CITY OF ALBUQUERQUE

December 4, 2023

Site: Calle Cuarta at 3525 4th St. NW (G14E097) – NMR1005D6

Re: Drainage Ordinance (14-5-2-11) Violations for Erosion and Sediment Control

AREA INLET PROTECTION

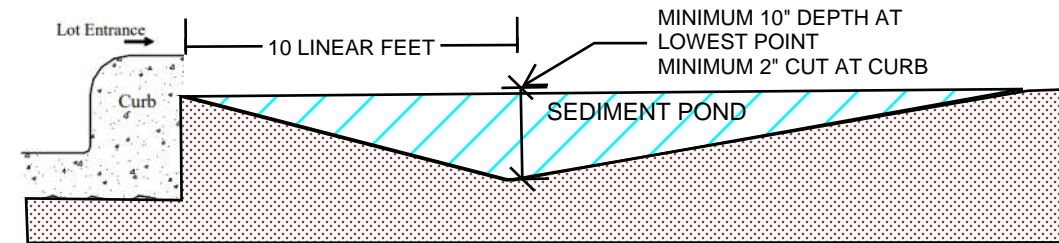
Inlet protection measures were missing. So they failed to remove sediment from this site prior to entering the storm drain inlets downstream from this site.

1. **BMPs** – Your track-out pad must be reset on filter fabric, with thicker layer of larger stone, and additional controls to restrict vehicle use to the properly designated exit point per CGP 2.2.4.a and 2.2.4.b. Implement additional track-out controls such as: preventing the use of exit points during wet periods, keeping vehicles (esp. the water truck) on-site, and limiting exit point size per CGP 2.2.4.c.
Install inlet protection measures that remove sediment prior to entry into any storm drain inlet per CGP 2.2.10.a. Inlet protection should create ponding upstream of the inlet without blocking the inlet. Clean, or remove and replace, the protection measures as sediment accumulates. Remove sediment by the end of the business day per CGP 2.2.10.b.
Ensure that all stormwater controls (BMPs) are maintained and remain in effective operating condition during permit coverage per CGP 2.1.4. If at any time you find that a stormwater control needs routine Maintenance, you must immediately initiate the needed maintenance work and complete such work by the close of the next business day. When the problem requires a new or replacement control or significant repair, install the new or modified control and make it operational, or complete the repair, by no later than seven (7) calendar days from the time of discovery per CGP 5.2.1.

STABILIZED CONSTRUCTION ENTRANCE

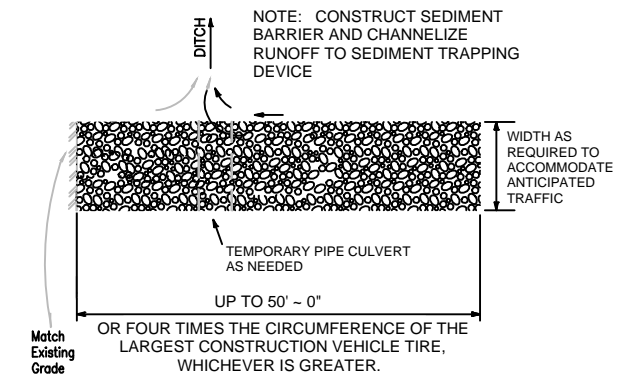
1. **BMPs** - Sediment track-out wasn't minimized in violation of CGP 2.2.4. Track-out controls failed to restrict vehicle use to the stabilized pad, vehicles drove off of the sides of the pad, in violation of CGP 2.2.4.a. The stabilization technique was inadequate, the rock layer was too thin, rock diameter was too small, filter fabric failed to prevent pumping of mud up through the rock, and pad next to street sank into the mud in violation of CGP 2.2.4.b.

2. Sediment wasn't removed prior to vehicles exiting your site in violation of CGP Part 2.2.4.c., so they tracked sediment into 7th Street. Next the sediment from your site was washed into a city storm drain inlet by a combination of stormwater runoff and potable wash water from a vehicle from your site.

2. **Sediment** - Where sediment has been tracked-out from your site onto paved roads, sidewalks, or other paved areas outside of your site, remove the deposited sediment by the end of the same business day in which the track-out occurs or by the end of the next business day if track-out occurs on a non-business day. Remove the track-out by sweeping, shoveling, or vacuuming these surfaces, or by using other similarly effective means of sediment removal. You are prohibited from hosing or sweeping tracked-out sediment into any storm drain inlet per CGP 2.2.4.d.
